## PLANNING CONSULTATION RESPONSE

Application No	2025/0820
Proposal	Change of use from dwellinghouse (Class C3) to 4 Child Children's Home (Class C2)
Address	18 - 20 Church Street, Royston, Barnsley, S71 4QU
Date of Consultation Reply	19 <sup>th</sup> December 2025
Consultee	Highways DC

[2<sup>nd</sup> Response]

Parking layout as amended

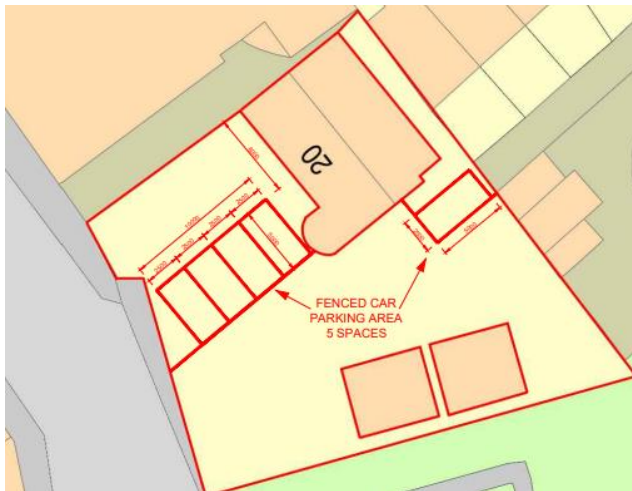
The Planning Statement refers to there being both four and five parking spaces within the site, it is assumed that four spaces are still proposed.

My previous concerns regarding the proposed parking arrangements within the site have not been addressed, it is stated that the parking area is covered in grasscrete, however, this does not appear to be the case given the location of the proposed four spaces. As can be seen in the image below, the four spaces are positioned partly on an area that starts to slope, and partly over a small retaining wall and raised patio area:

The site layout plan is shown below for comparison, demonstrating that the above image is an accurate reflection of the proposed location of the four parking spaces.

As per my previous comments, a more detailed plan should be provided, suitably demonstrating how the parking spaces are to be created (i.e. with the use of a retaining wall to create a level area) and also the proposed surface treatment (please note that the surface must be of a solid bound material and that gravel/loose chippings are not permitted).
